Our ref: Q210843
Your ref: 23/02098/OUT
Email: Matthew.sharpe@quod.com
Date: 29th October 2024

23/02098/OUT – Applicant response to Environment Agency email dated 2 July 2024

Appendix 1: Detailed Response to EA Comments dated 28 August 2024

Figure 6.1: Location of Swale in the North-west of the site

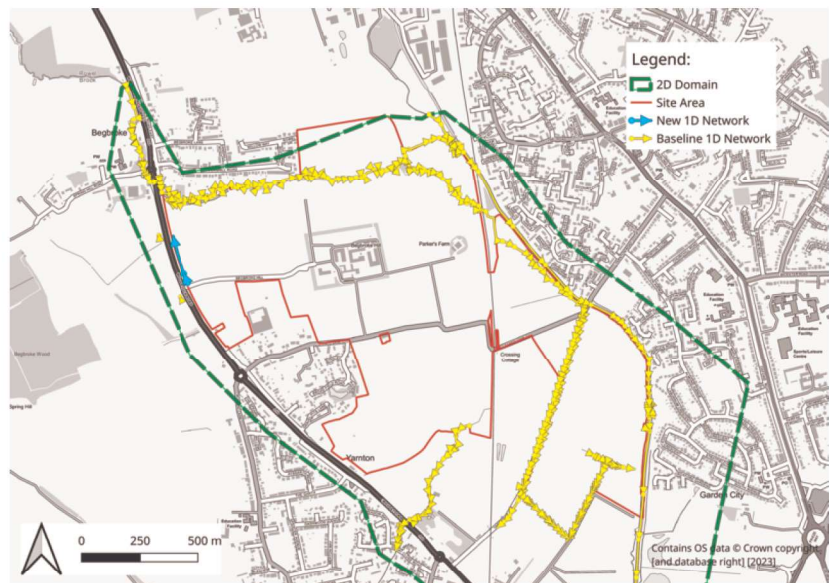
EA Response (28 August 2024)	Applicant Response
<p>North-west of site – Proposed Swale</p> <p>The applicant proposes to obstruct a flow route in the northwest of the site, which is likely to increase flood risk elsewhere as the displaced flood water would find a new flow route. We would expect level for level compensation to be proposed for the loss of floodplain storage (the area that will be prevented from flooding). Instead, a swale is proposed, and it is unclear how the swale would function. If the water is channelled into a narrow ditch, this could increase the efficiency of flood flows, moving more water downstream at a greater rate which could increase flood risk elsewhere. It may be the swale would be designed to mimic the existing flood flow, however this would need to be demonstrated through modelling and plans clearly identifying how the swale would function. Further information is therefore required in order to show there would be no detriment, including considering timing of any flooding offsite.</p> <p>Further, whilst attenuating the displaced flood water in a swale may hold water upstream in an initial rainfall event, if the attenuation area/swale cannot freely drain into the river then there may be less storage available for any future floodwater should there be further rainfall event. This could also increase flood risk elsewhere. We would not have these concerns if level for level compensation was proposed, as flood water would be able to freely enter and exit the floodplain storage area during and after an event.</p> <p>More information is therefore required on the proposed swale unless, ideally, it can be replaced with level for level compensation.</p>	<p>We consider the EA's objection to the proposed swale to be unreasonable. Hydraulic modelling presented in the FRA and Technical Notes demonstrates that the swale acts to re-route flood water crossing the site, without any increase to offsite flood risk.</p> <p>The function of the swale was explained clearly in the meeting held with the EA (18th July 2024) including the concerns about water remaining in the swale between consecutive events. The detailed design of this would be secured by a planning condition that has been agreed between the LPA and the Applicant.</p>

<ul style="list-style-type: none"> • An explanation and plans that demonstrate how the swale would function in practise, clearly setting out the design principles. This should include whether the swale would be hydraulically connected to the floodplain or watercourses. Would the scheme change the timing of a flood event? If so, what would the impacts be? Would it create a more efficient flow path, increasing flows downstream? • How would the works affect the A44? Would there be any benefits of the scheme? 	<p>The detailed design of this mitigation measure would be secured by a planning condition that has been agreed between the LPA and the Applicant.</p> <p>It is noted that the solution has been hydraulically modelled for all design events outlined in the FRA and Hydraulic Model Report. The solution has been designed in a way so as to not increase flood risk downstream, which has been demonstrated. It was clarified to the EA in our meeting in July that the swale would not affect the A44. The Planning Conditions agreed with the LPA then secure this commitment.</p>

Figure 6.5: Difference in flood level between the baseline model and the North-west mitigation scenario in the 1% AEP event plus 41% allowance for climate change, 11 hour storm duration

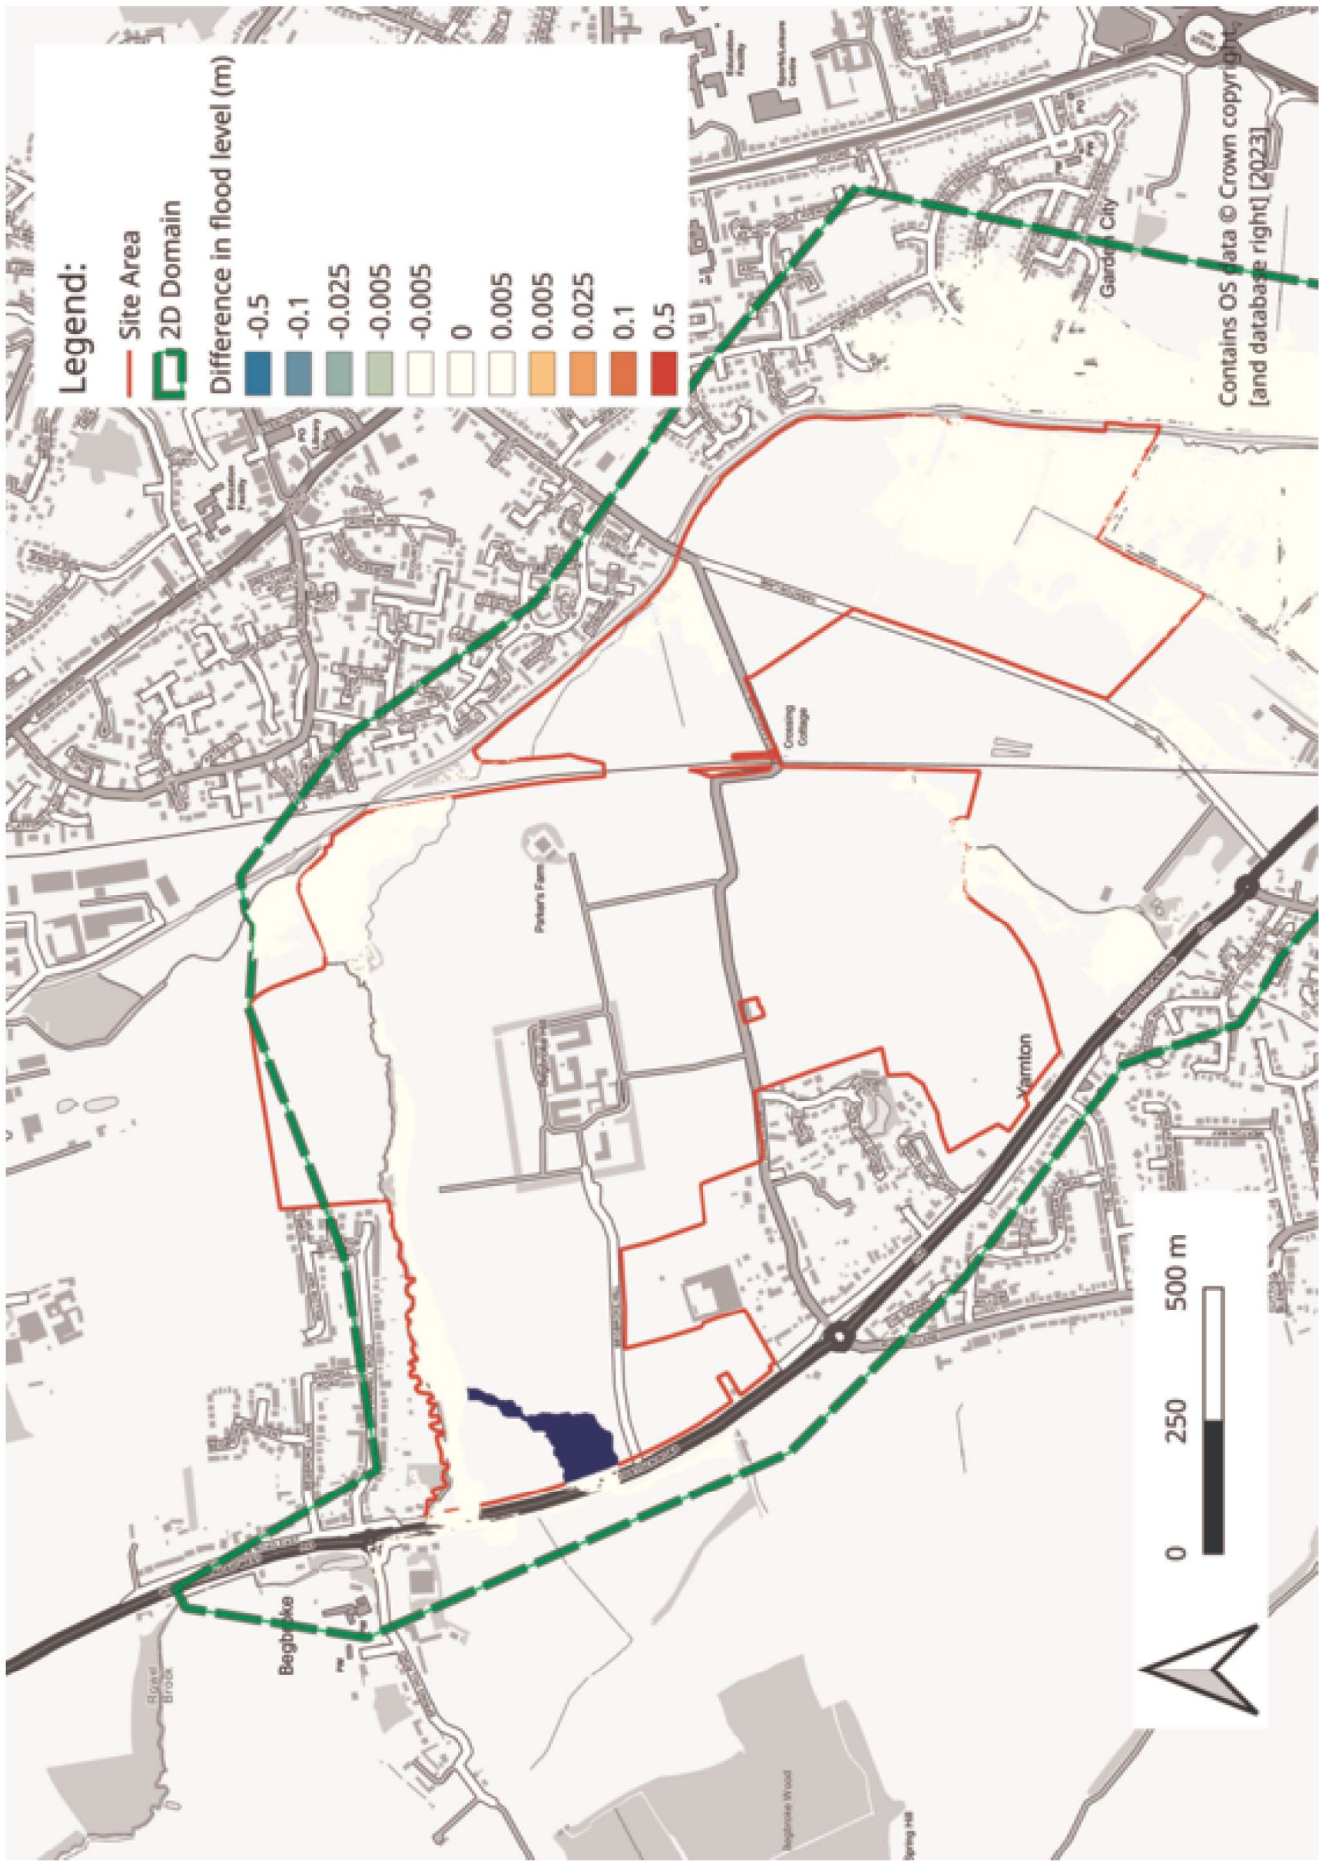
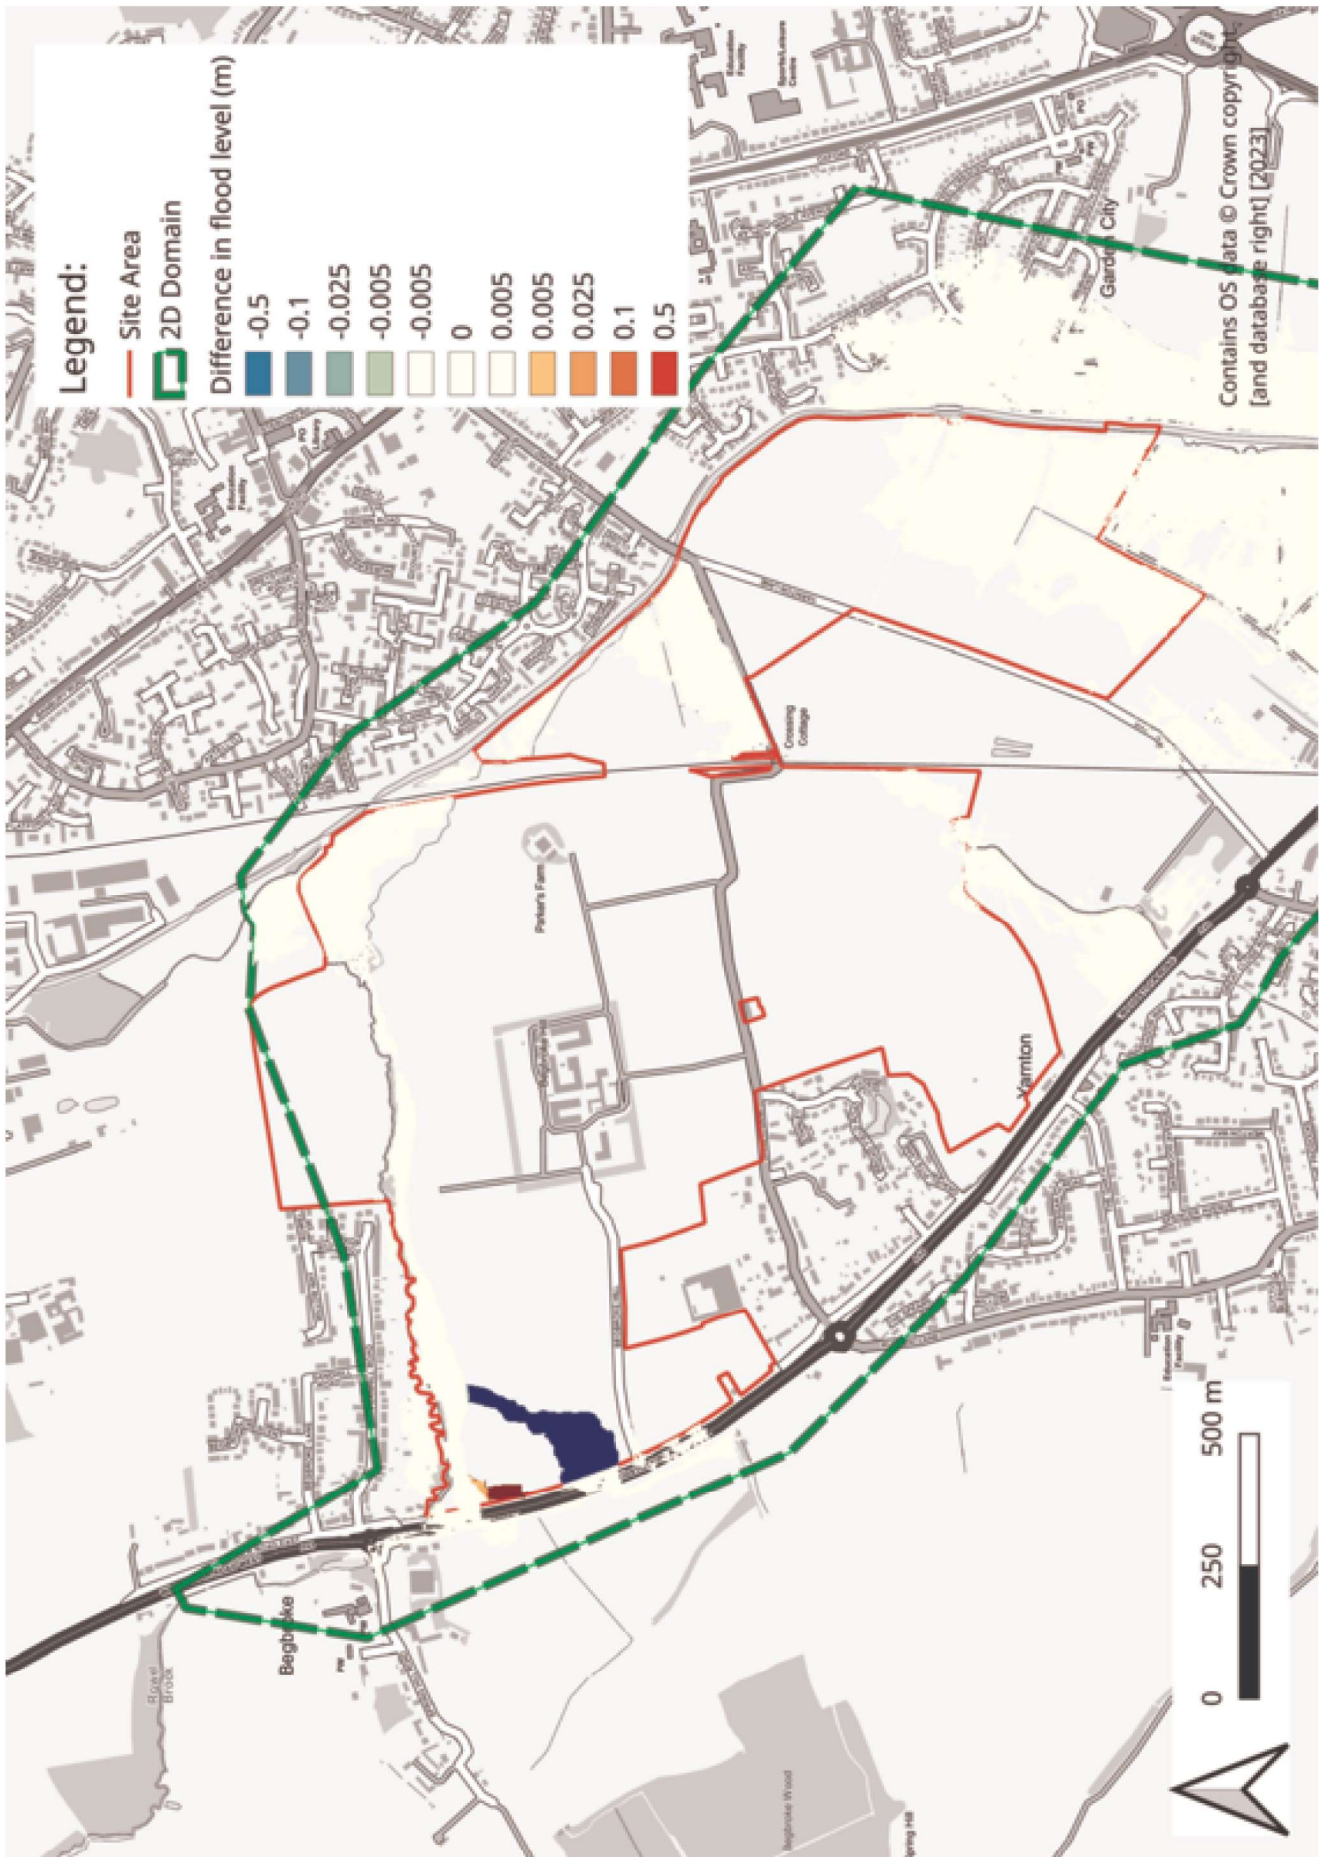
<p>We have provided the following comments for if a swale is the only mitigation feasible option and the applicant can demonstrate there would be no detriment. The submitted Design Note highlights 'difference plots presenting difference in modelled flood depths</p>	<p>The EA note that difference plots have been provided to demonstrate the results of the hydraulic modelling, showing no increased risk as a result of the swale but note that the resolution of the figures do not allow them to be content with the swale's impact. It is felt that these difference plots and associated dialogue clearly</p>

EA Response (28 August 2024)	Applicant Response
<p>and extents shown in Figure 6.5 and 6.6 of the updated Hydraulic Modelling Report’.</p> <p>Unfortunately, the resolution of these figures in the Model Report are too low for us to review (the proposed swale is not distinguishable from the RLB). Please can you request high resolution versions of these figures are provided. This mapping should clearly identify where the swale is proposed and what impact the works would have on flood risk on and offsite.</p>	<p>demonstrate there would be no increased risk in flooding offsite, or any other unacceptable flood risk impact.</p>
<p>In addition, the applicant should also provide more information on the proposed swale including:</p>	
<ul style="list-style-type: none"> • In relation to the 6.5 of the Design Note, the flow route of the ordinary course on the other side of the A44 is not clear. Our mapping identifies a culvert under the A44 and across the site, broadly following the flood extent shown during the 0.1% AEP event. There is limited information in section 4 of the Model Report: • does this watercourse go into a culvert, and if so, where does this culvert discharge? • If this culvert is present, what capacity does it have? The flow route across the road may be due to a low point in the road at the same height as the watercourse being bank full, or the culvert surcharging and levels increasing in the upstream reach before overtopping. Is there open channel on either side of the A44 connecting the ordinary watercourse to the Rowel Brook in the north? • Note any key details set out in the Model Report should also be set out in the FRA to explain the principle of what is proposed. 	<p>As noted in the response provided on 21 June 2024, “The evidence provided to date including site survey information indicates that there is no culvert in this location. The EA have provided no evidence to the contrary.” This remains the case that the EA have not provided further information to be considered. The detailed hydraulic modelling considers site specific topographic survey information. The EA have been provided with the hydraulic modelling and the hydraulic modelling report for review and are therefore able to identify the model build in this area. It is not considered necessary to replicate the model build information from the modelling report in the FRA.</p>

EA Response (28 August 2024)	Applicant Response
<p>maintained such that the floodplain will function as it does in the pre-development scenario.</p>	<p><i>recommend that an additional plan is provided to show the difference in modelled flood depths and extents, as well as the location and design of the proposed swale.</i></p> <p>It was confirmed in our responses provided on 21 June 2024 that <i>“The design of the swale was outlined in the original FRA. Please refer to the difference plots presenting difference in modelled flood depths and extents which are shown in Figure 6.5 and 6.6 of the updated Hydraulic Modelling Report”</i>. The Planning Conditions agreed with the LPA then secure these commitments.</p> <p>Excluding the extent to the north-west corner of the site, closest to Rowel Brook, in the pre-development scenario, there is no flood extent within the red line boundary originating from offsite for flood events lower than the 1 in 100 year plus climate change. The swale is designed to capture, attenuate and discharge the flows into Rowel Brook in a controlled way for flood events from between the 1 in 100 year and 1 in 1000 year. This is demonstrated in Figure 5-3 and 5-4 of the BH Technical Note – Responses to EA Consultation on Flood Risk (12 March 2024).</p>
